Please ask for: Mrs D Johnson  
Email: [daun.johnson@arun.gov.uk](mailto:daun.johnson@arun.gov.uk)  
Telephone: 01903 737762  
Our Ref: LU/57/25/PD  
Your Ref:  
Date: 18th March 2025

**Prior Notification for Permitted Development**

**Development:** Prior notification under Schedule 2, Part 3, Class MA for the change of use of part of building on ground floor from restaurant (Class E) to dwelling house (Class C3).  
**Location:** 51 Pier Road Littlehampton BN17 5LP

Ground Floor Plan - Proposed

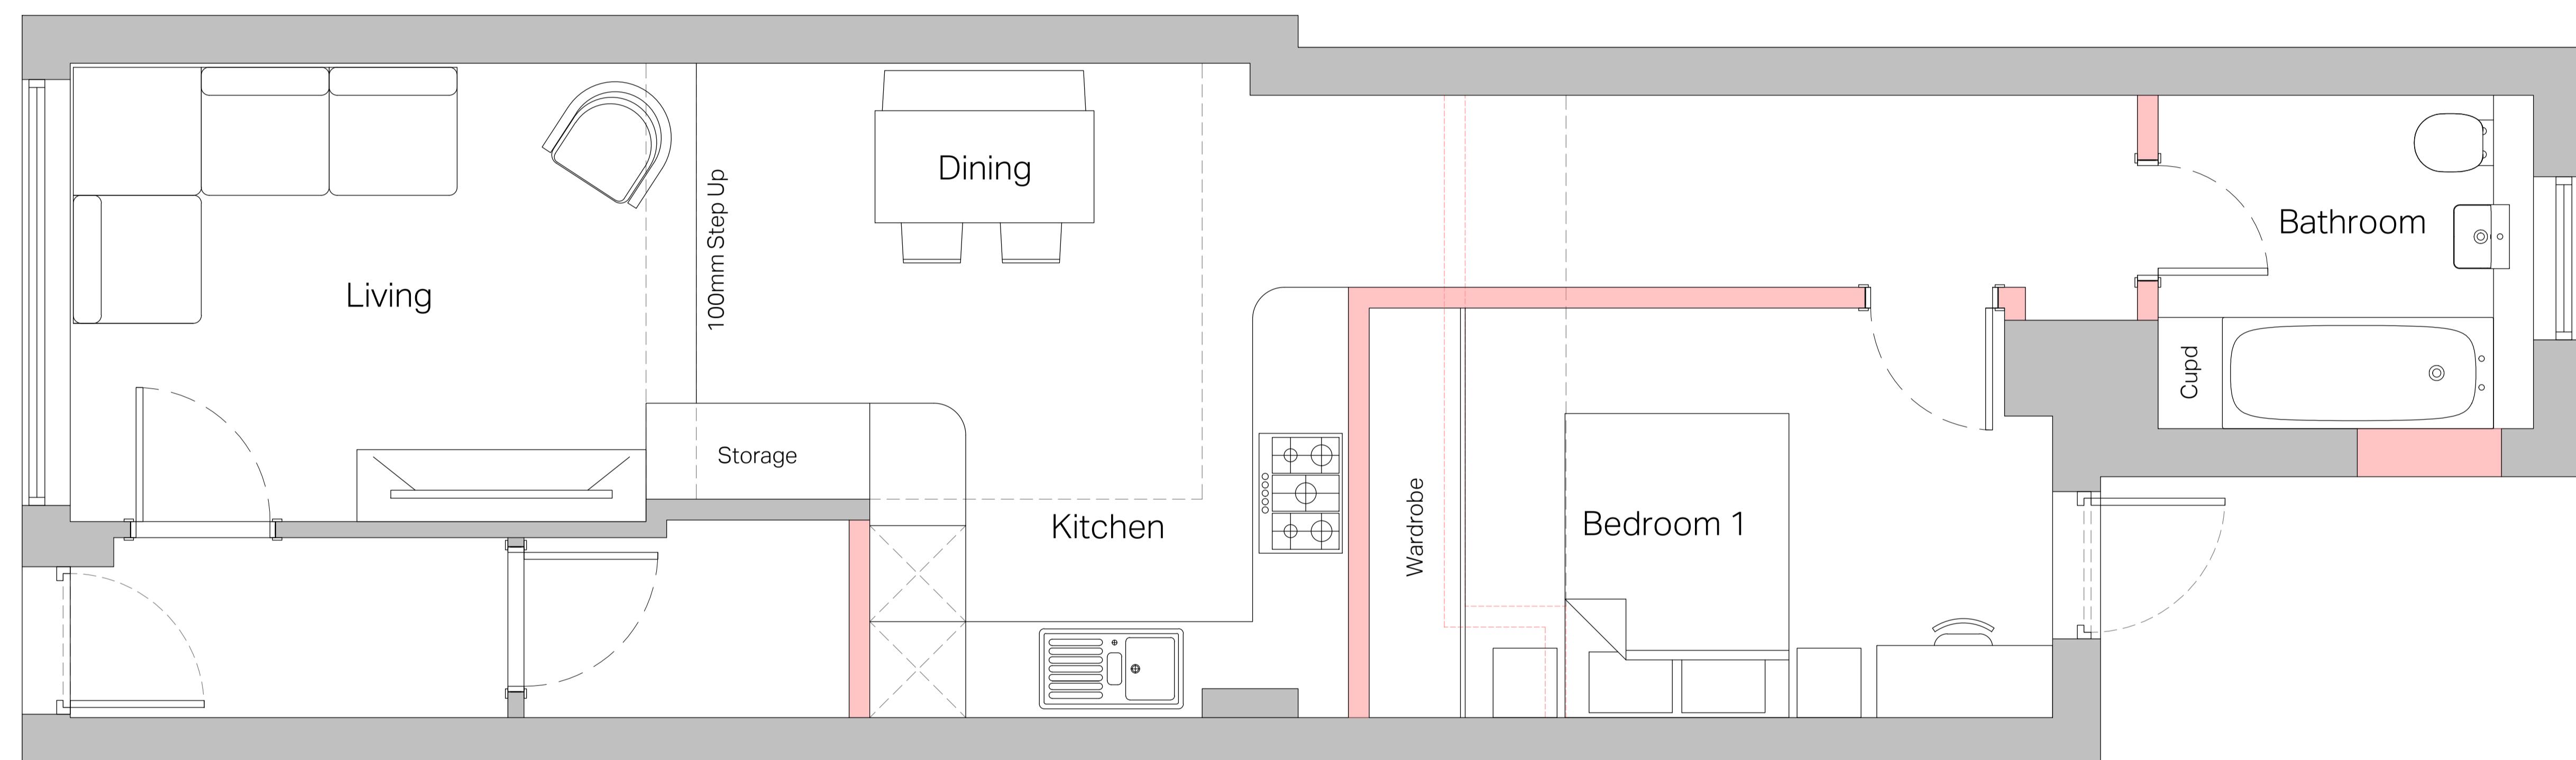
On the proposed floor plan, please provide the dimensions of all windows and doors.
